Submission: Mamre Road Data Centre Campus SSD-92743706

Reference is made to the State Significant Development Application (SSD- 92743706) for the proposed data centre campus at 706-752 Mamre Road, Kemps Creek. Thank you for accepting this late submission.

6 SECTION FF - FREIGHT CORRIDOR RESERVE SCALE 1:50

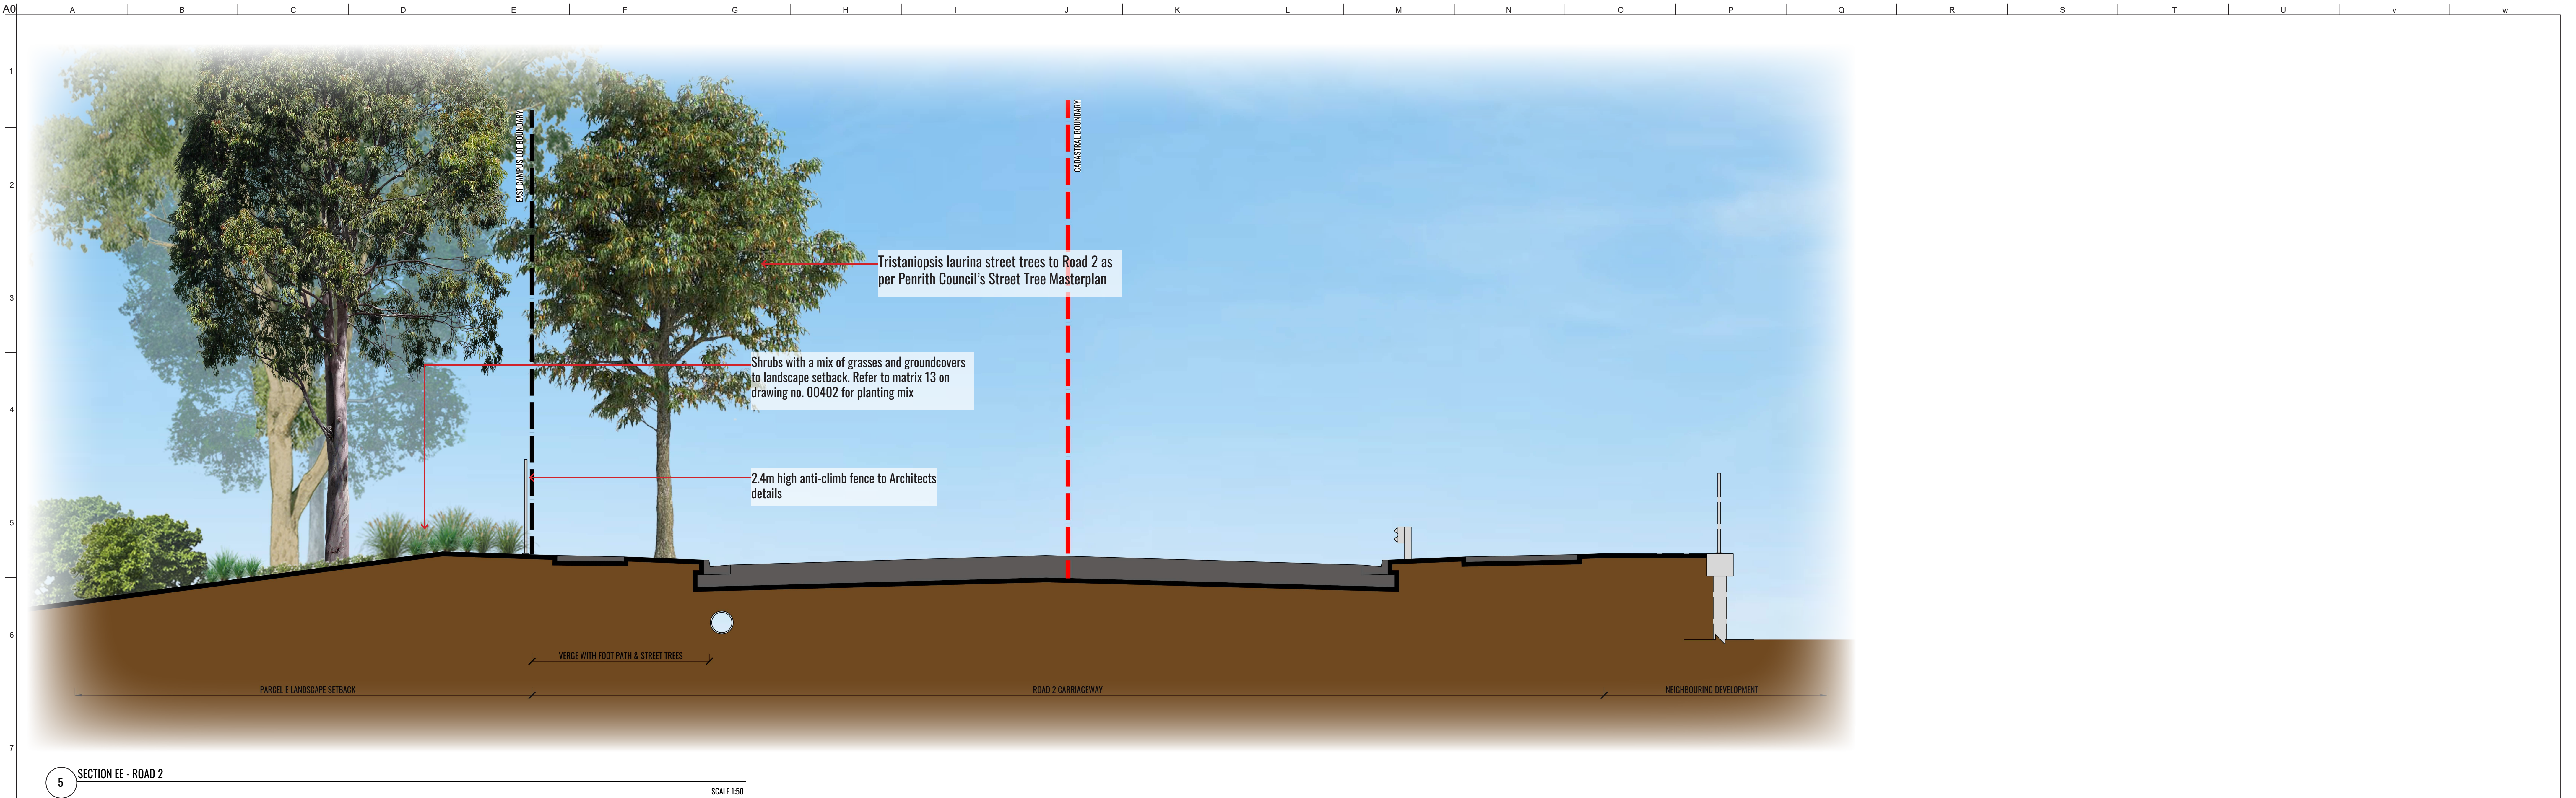
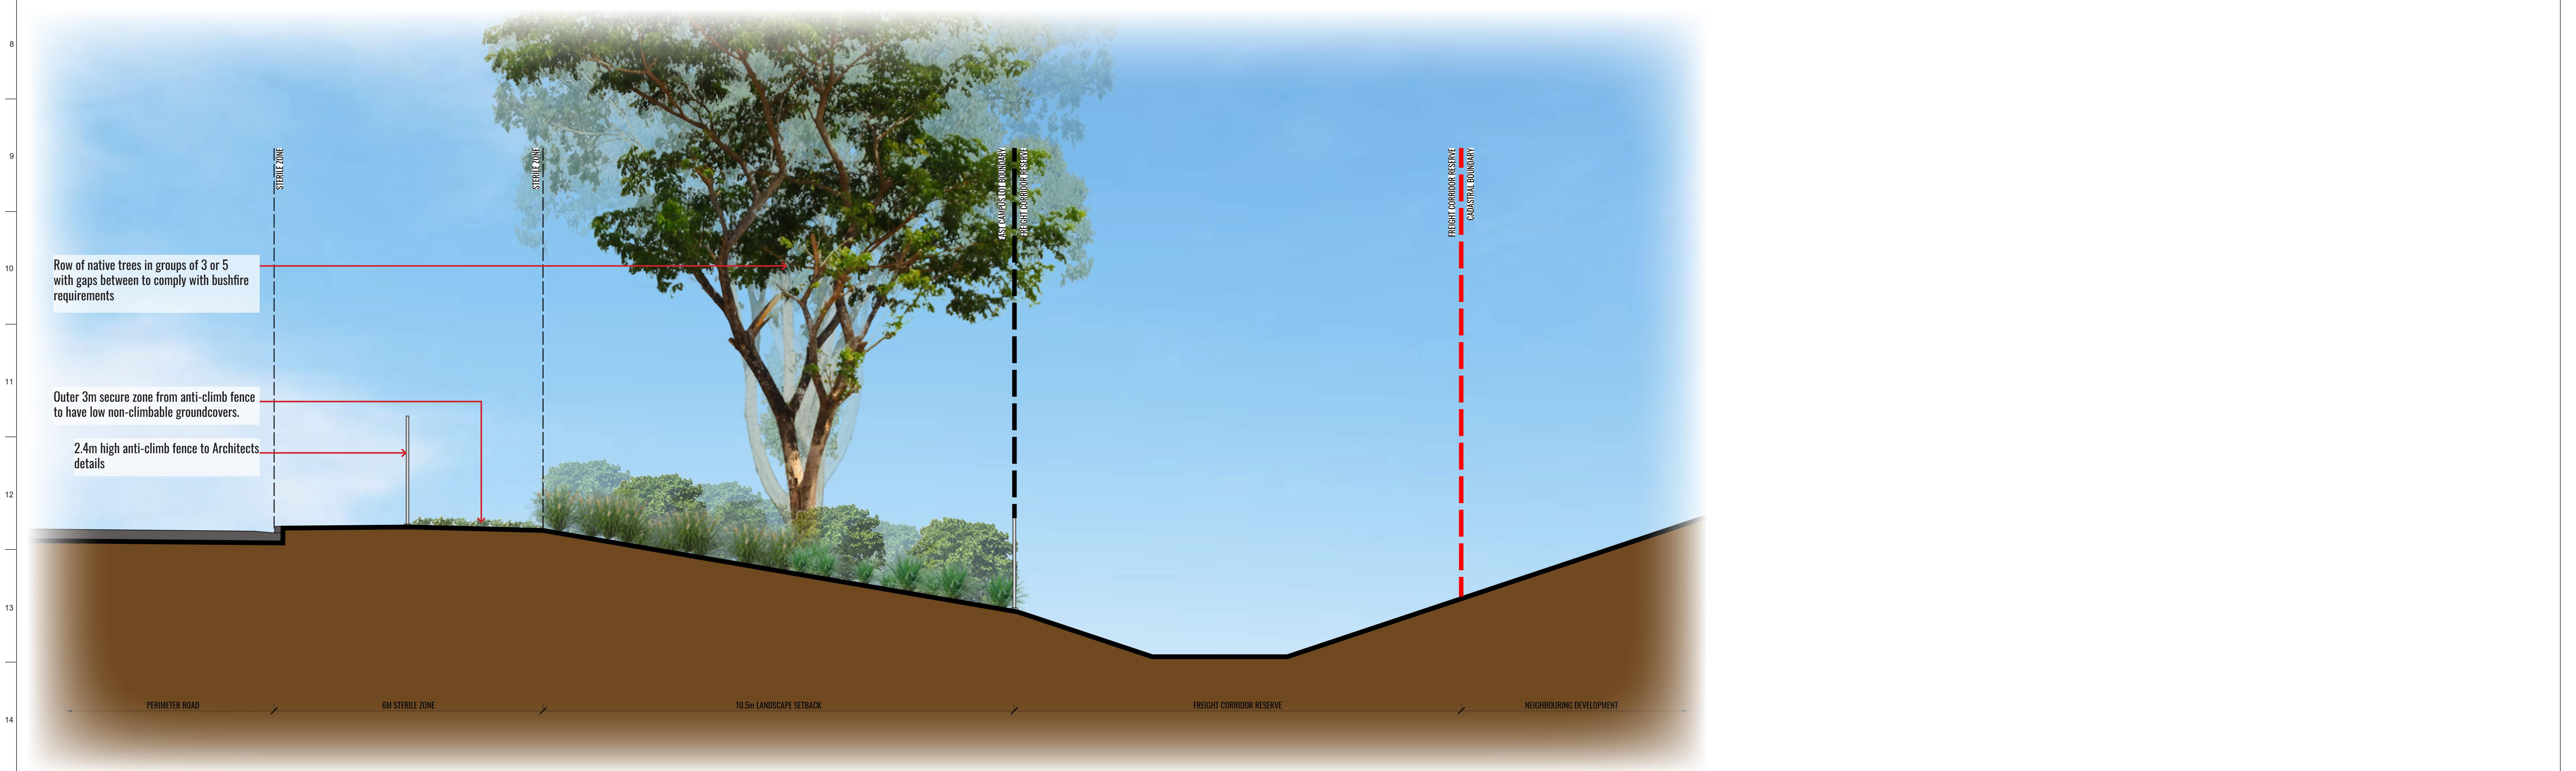
- The Site is part of the 'dedicated freight network' as it is serviced by the proposed dedicated freight corridor.
- The proposal has not demonstrated how access to and from the dedicated freight corridor will be achieved as required under Control 5 of the Mamre Road DCP.
- The proposed Road 2 encroaches within the required 10m reserved freight corridor.
